Topic	PF Response
WSCC First round of questions (Additional comments received from WSCC in Red, PF responses in Blue)	
1. Design speed – This is still quoted as 30mph. However, no reference to the WSCC Speed Limit Policy is provided. As such, the applicants should set-out whether-or-not the new A29 road accords with that Policy.	The Design of the A29 is seeking to align with WSCC Speed Limit Policy, however it should be noted there are some outside influences which has impacted and shaped the design process. Further to various meetings with WSCC on the road design in 2019 and 2020 and prior to the submission of the Planning Application there was an agreement between WSCC highways team, WSCC A29 delivery team and The Southern Consortium that the A29 would be subject to a 30mph design speed. Reference to these discussions are highlighted in our Design Statement. In line with WSCC Speed limit policy the main elements are, the road will need to demonstrate that any design speed chosen is self-enforcing and this will

A29 BEW Rail Bridge (WSCC structure ref; 1779). Options Report

Drawing Title
**INITIAL BRIDGE OPTIONS
MULTI SPAN**

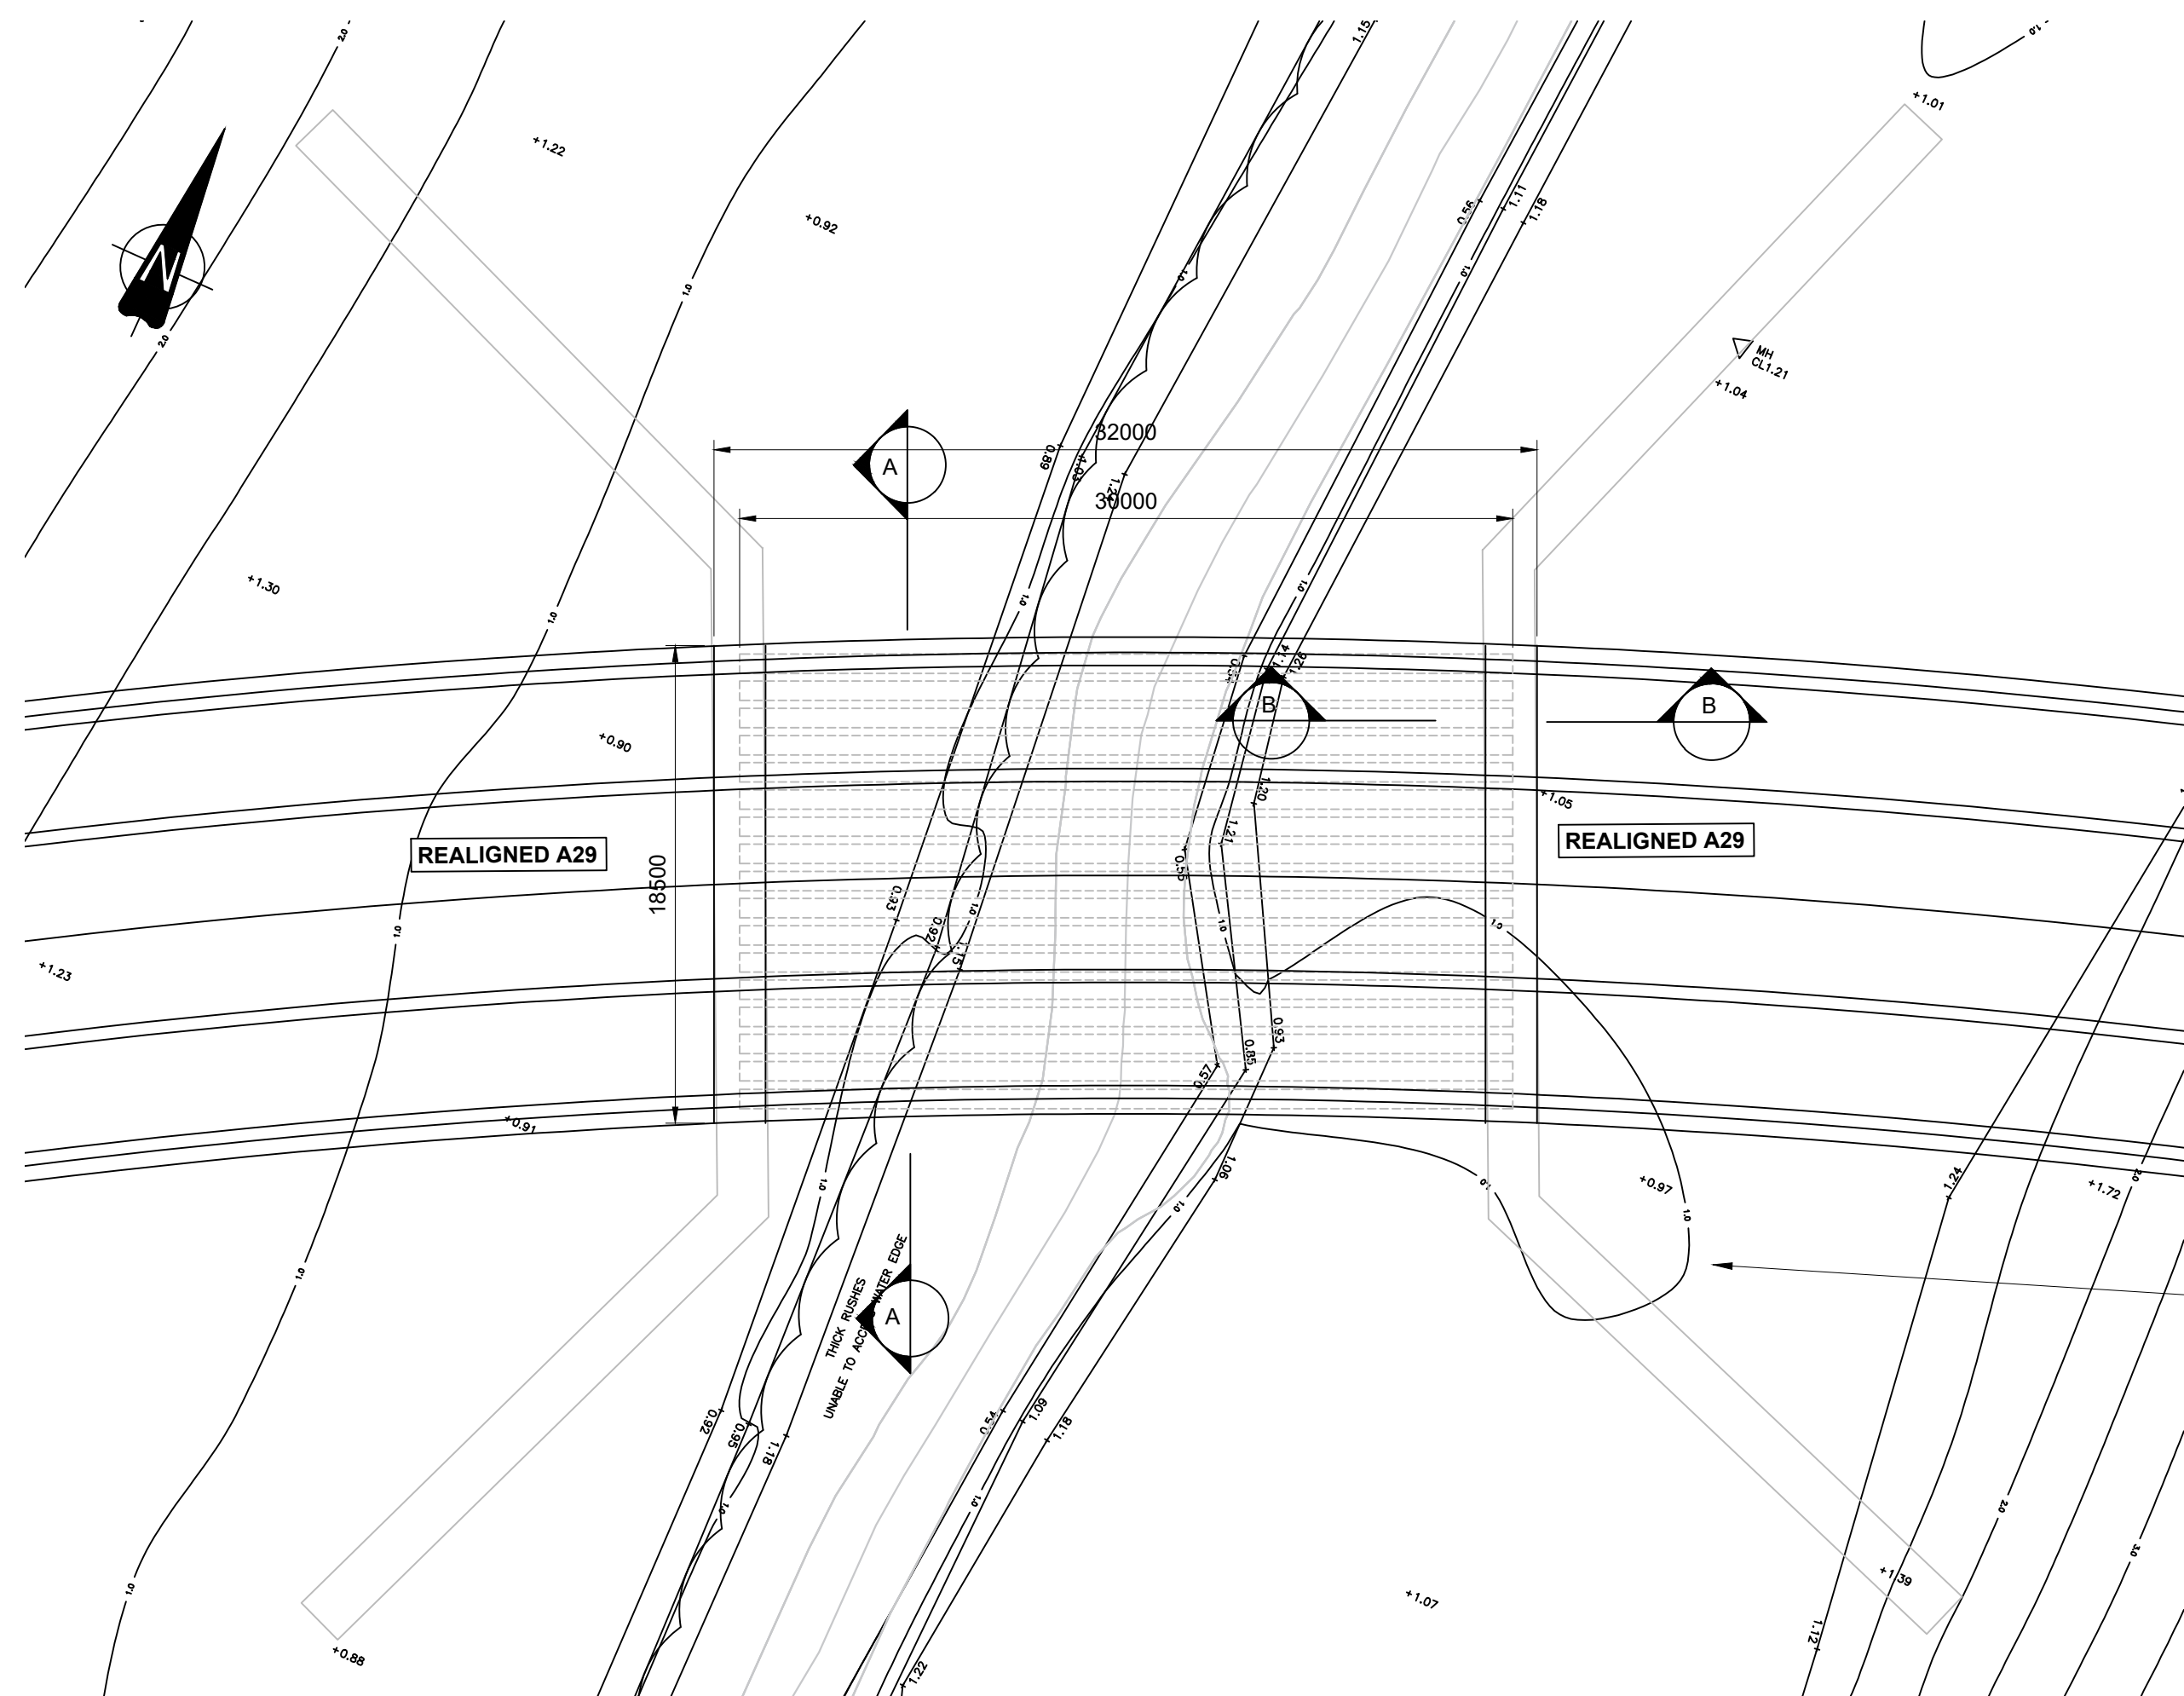
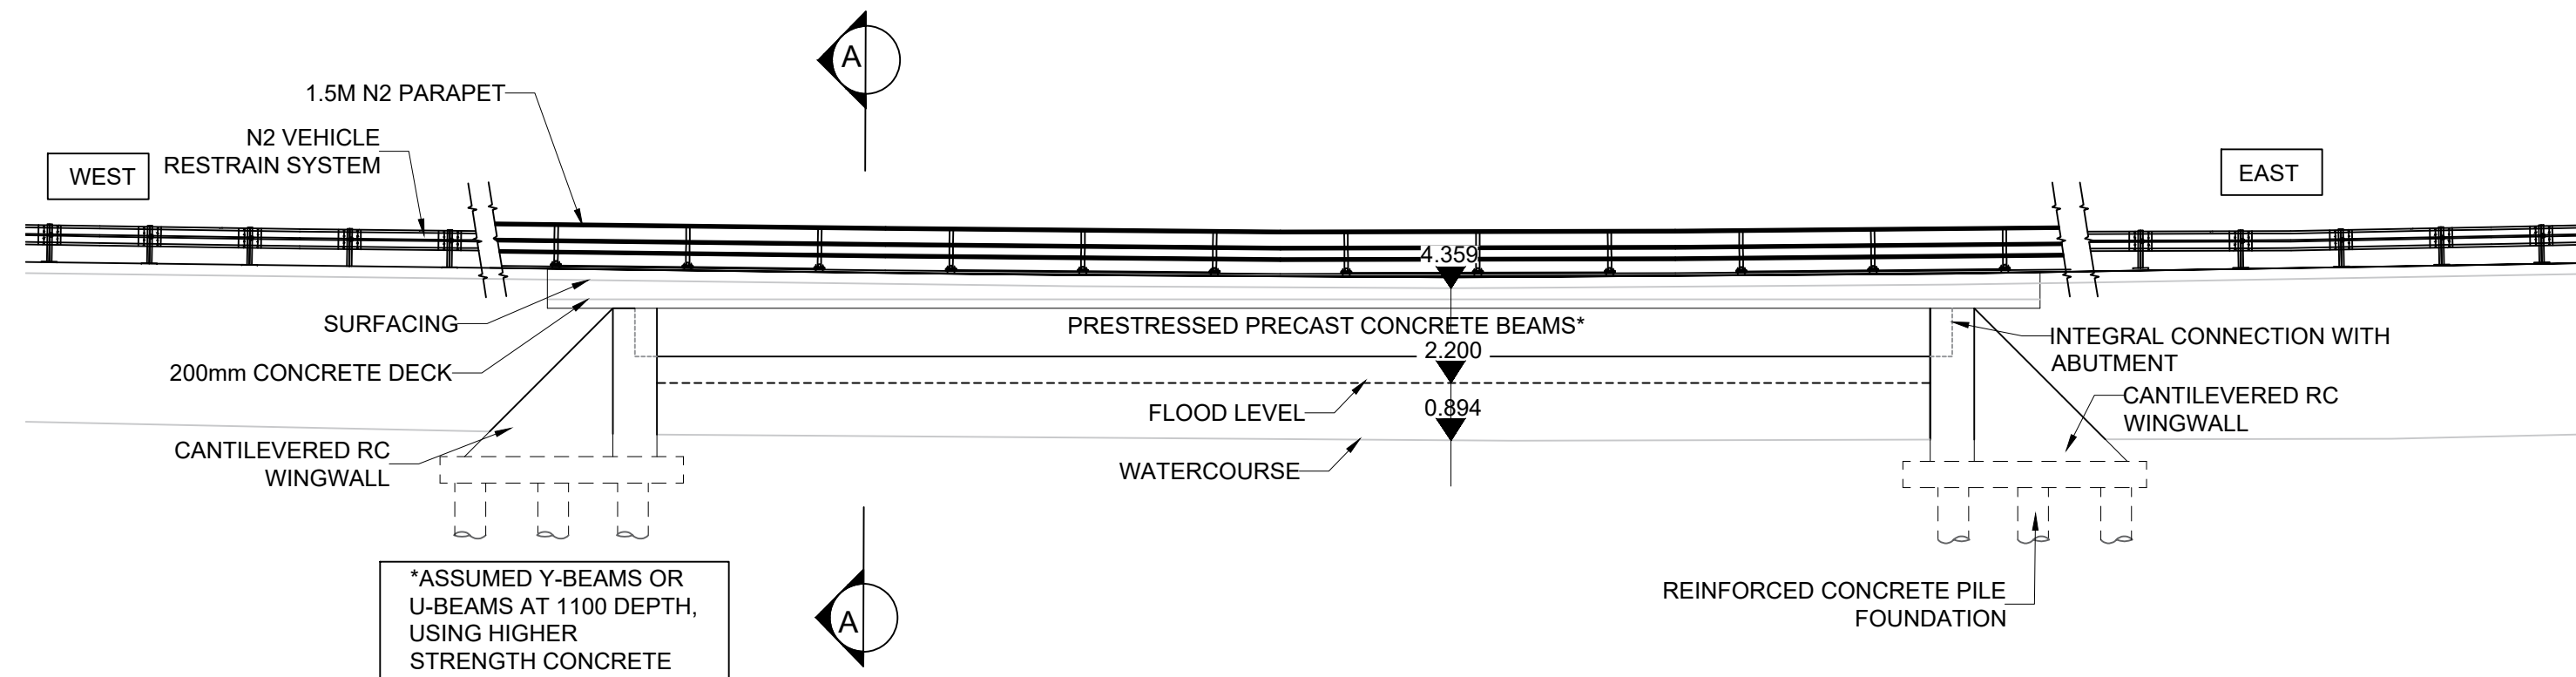
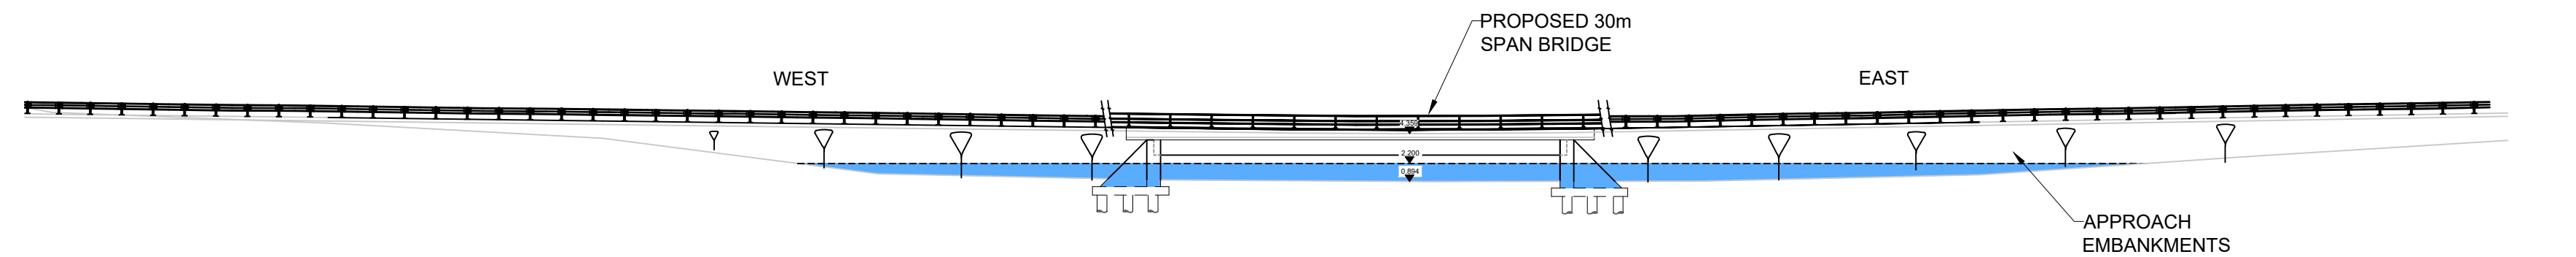
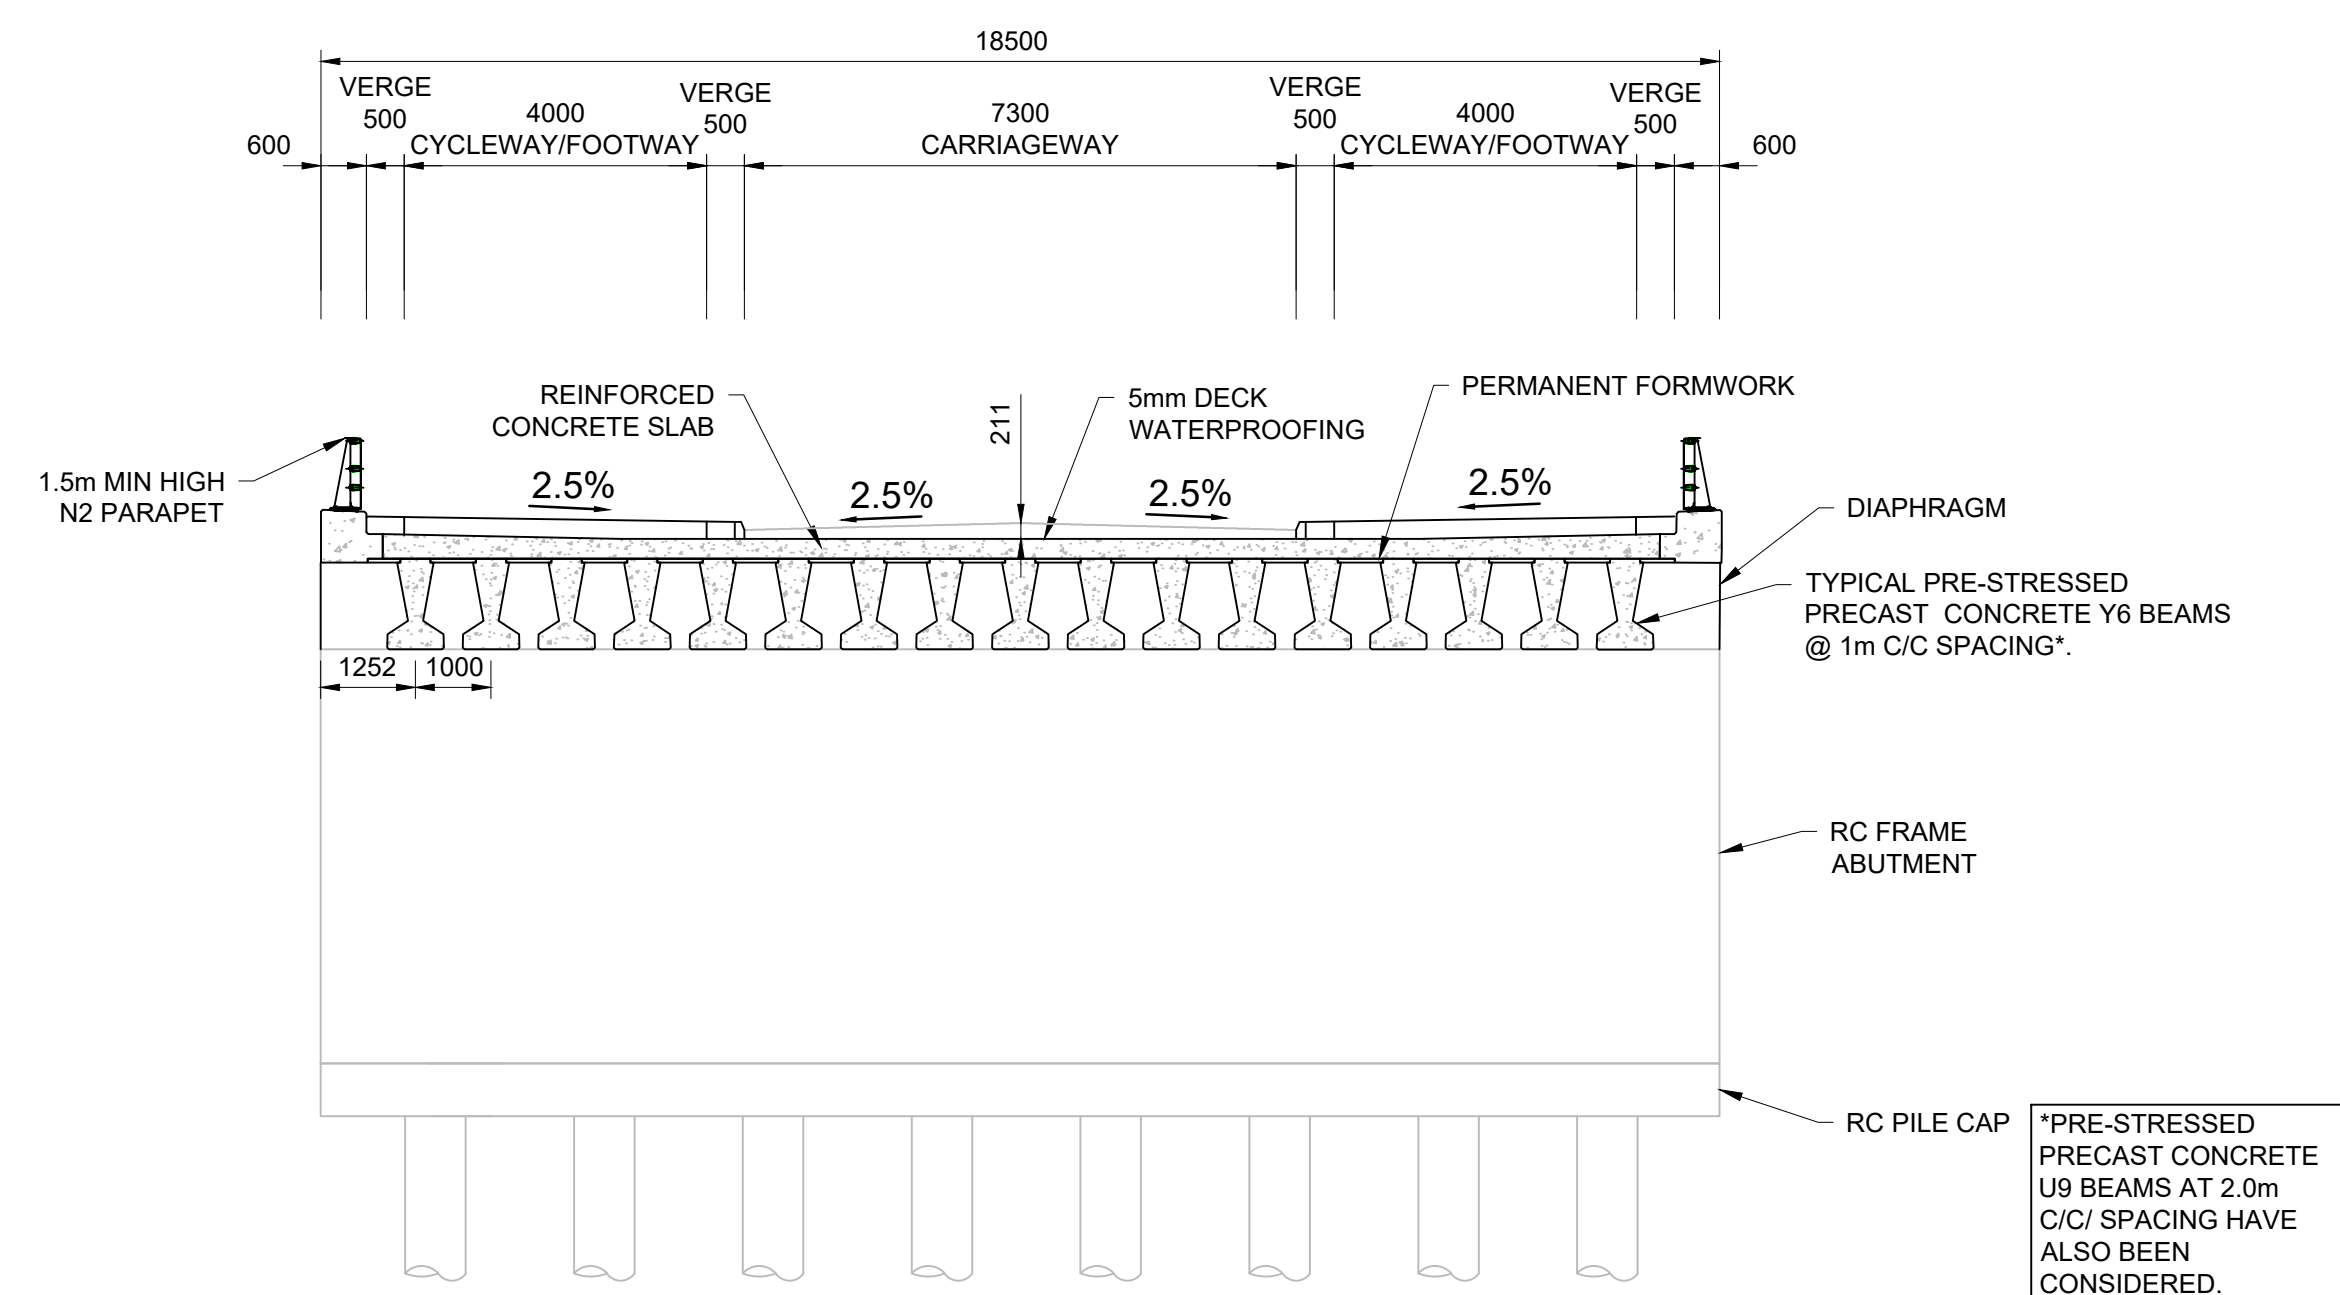
The Technical Note (TN) is geared towards either a) a 200m long multi-span viaduct, or b) 30m single span structure. The reason for the massive variance is as stated in the front of the report, see screen grab below.

Given as much, the vast majority of the content of the TN is of limited use as it only discusses 1 No. viable option. The TN should have addressed various single span options (weathering steel, U or W beams similar to the Options Report for the rail bridge). As a result, the drawing is certainly of interest but also of limited value (in the context of 'options'). Perhaps the river bridge could basically be a repeat of the rail bridge (the widths should be identical and the spans are very similar)?

However, recent discussions with the Environment Agency have reduced to the flood level to 2.2m AOD at point of crossing. As a result, the structure clearance can be reduced and therefore the multi-span bridge is no longer a viable option. For information purposes, the multi-span structure proposal is included within the report.

Technical Note updated as required.
